Consultation Response from KC, Lead Local Flood Authority		
2020/91468 Former North Bierley Waste Water Treatment Works, Oakenshaw, BD12 7ET		
Discharge of conditions 5 (Phasing Plan), 11 (Sewer Overflow), 13 (Foul Water Drainage), 14 (Discharge of Surface Water), 23 (Flood Risk) and 24 (Disposal of Surface Water) on previous permission 2016/92298 for outline application for re-development of former waste water treatment works following demolition of existing structures to provide employment uses (use classes B1(c), B2 and B8)		
Date Responded: 24/11/2020	Responding Officer: Alex Fraser	Responding Ref: R02

Kirklees LLFA Summary

S38 GENERAL ARRANGEMENT

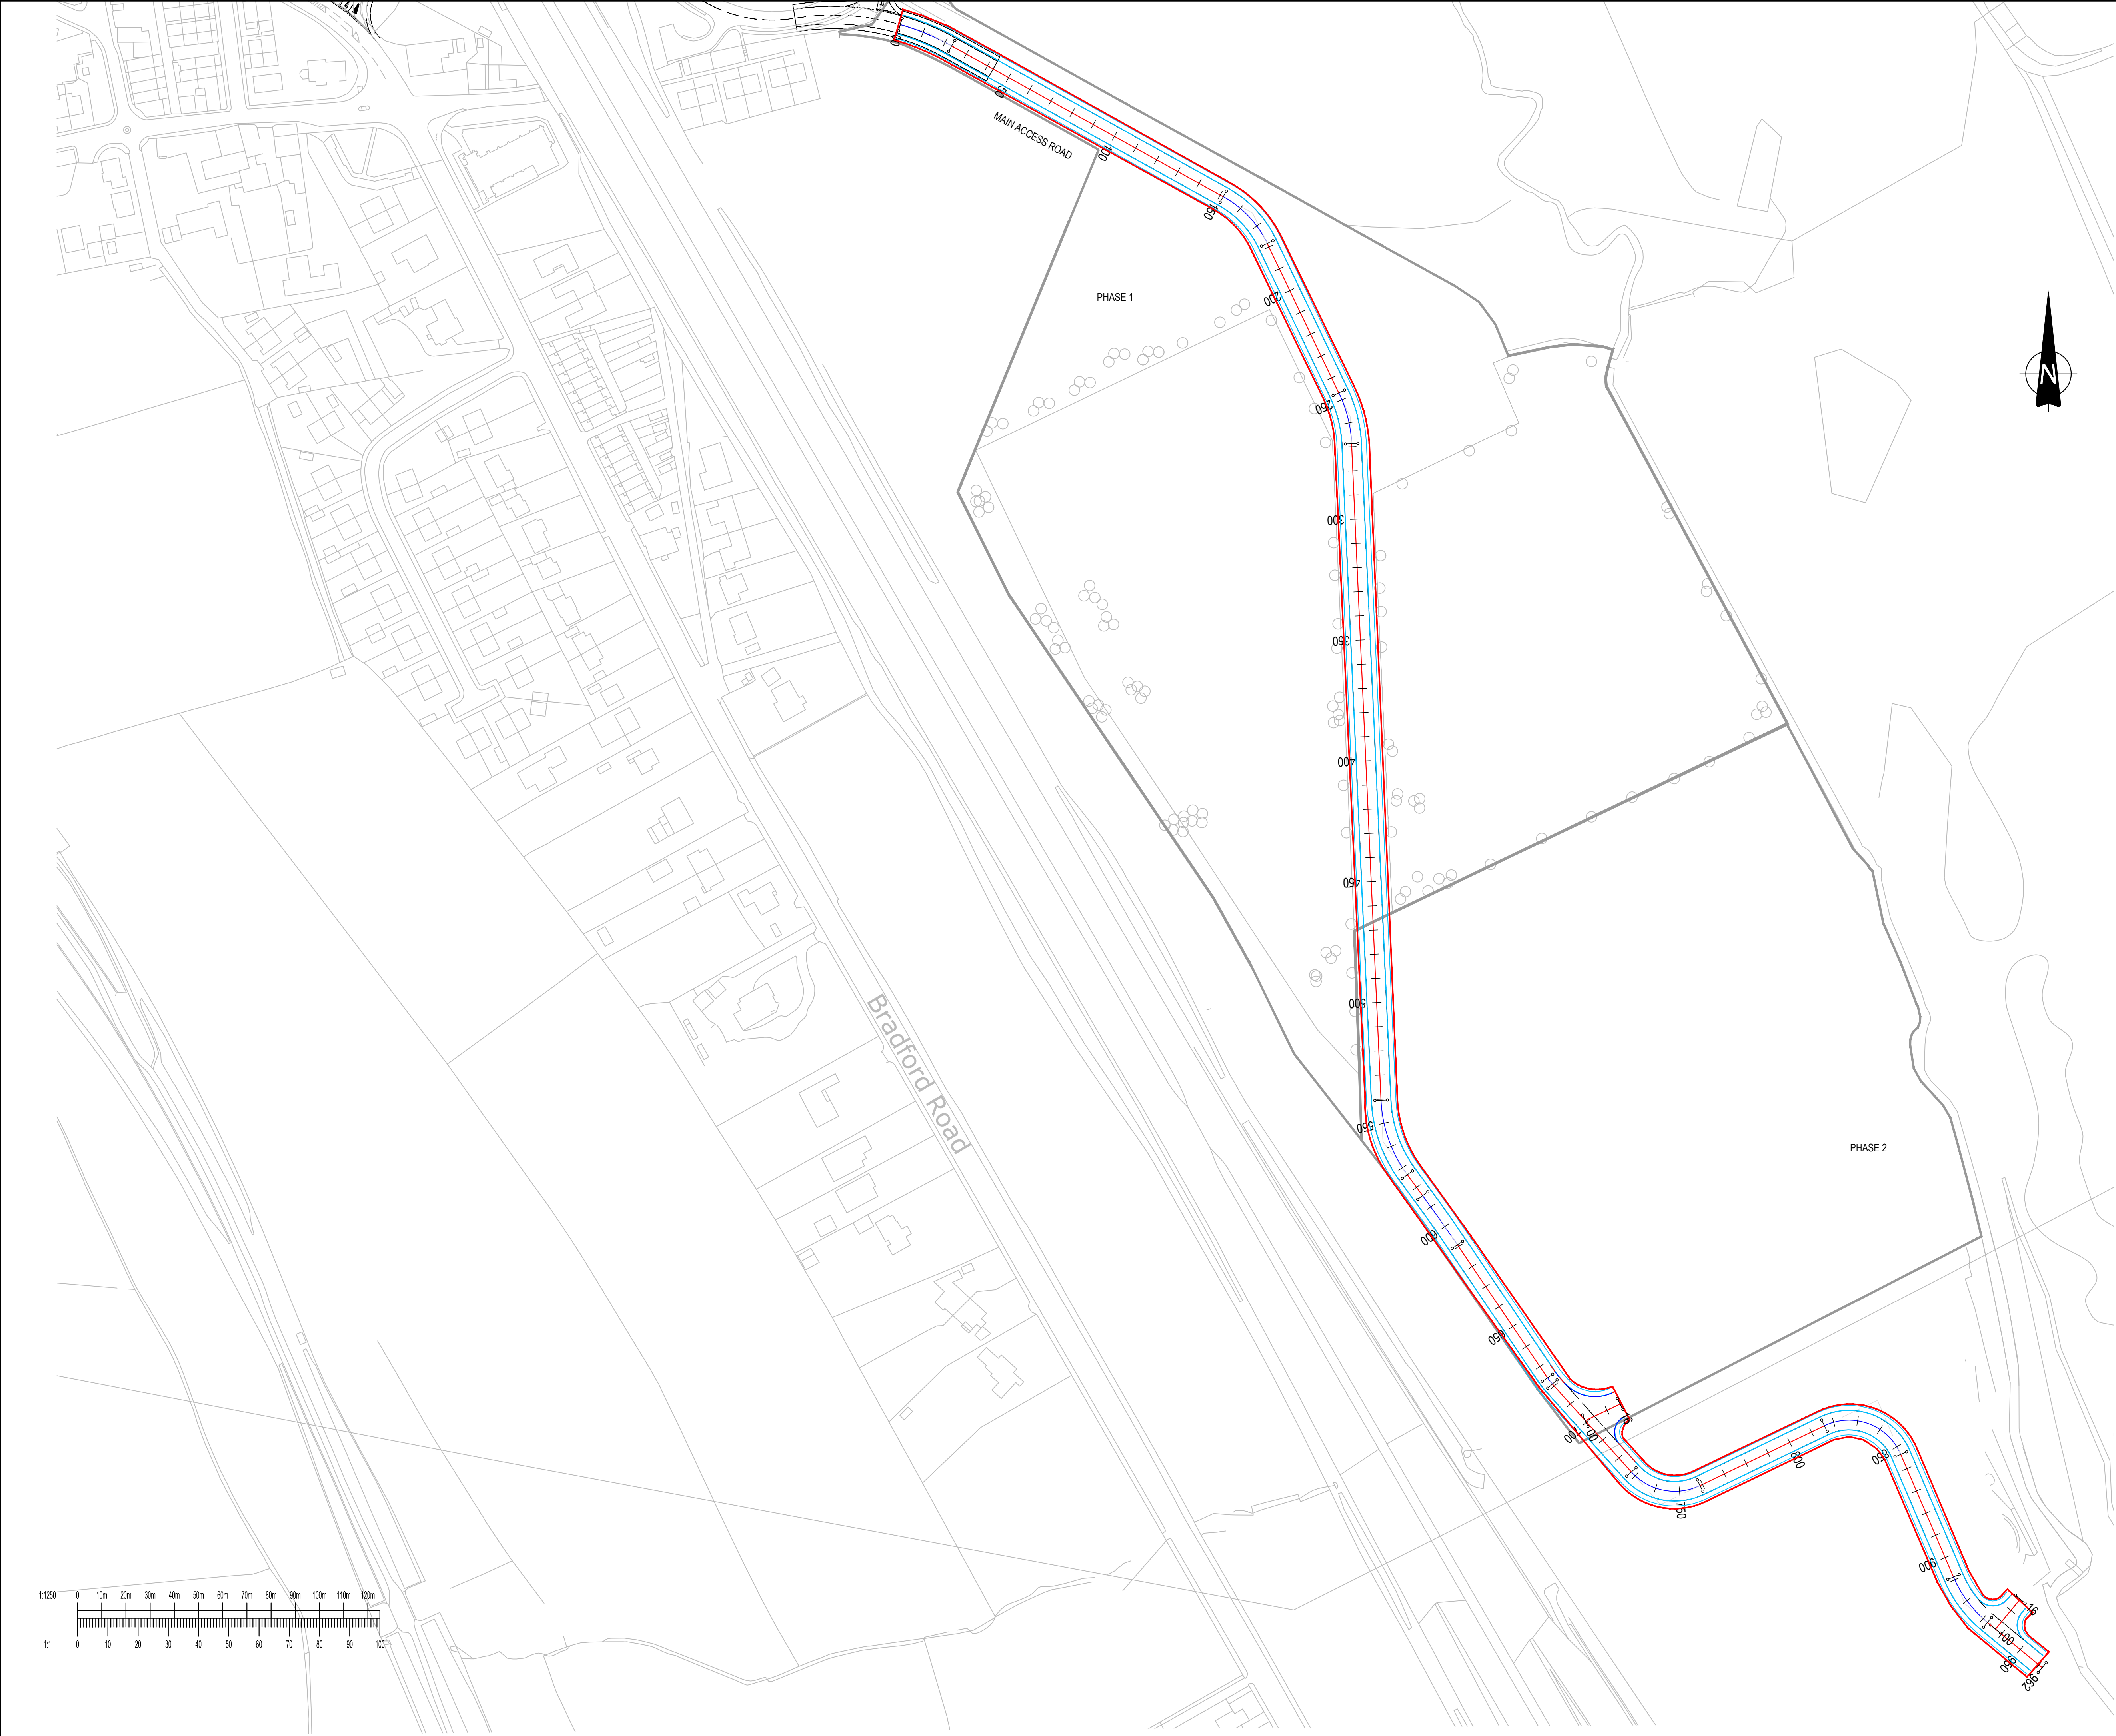
Kirklees LLFA Comment: Kirklees LLFA have no objection to the drainage design proposals with a restricted discharge for all events up to the 1 in 100-year plus climate change, with attenuation being provided in oversized pipes located under the access road.

The design shows that discharge from the Northern part of the site will be restricted to 24.5l/s, design drawings also show the concept for the private drainage connecting into the carriageway system at 7l/s. Discussions around the development design on each plot may require the 7l/s to go direct to the watercourse instead of via the road system, if this is the case then the 24.5l/s will need to be reduced further and another flow control swapped into the system.

This original design has been superseded with the attenuation now being used as compensatory storage for the development plateaus. Refinement of the modelling could provide greater understanding of the system meaning the compensatory storage area could revert to an attenuation basin once the flood risk is better understood from the watercourse.
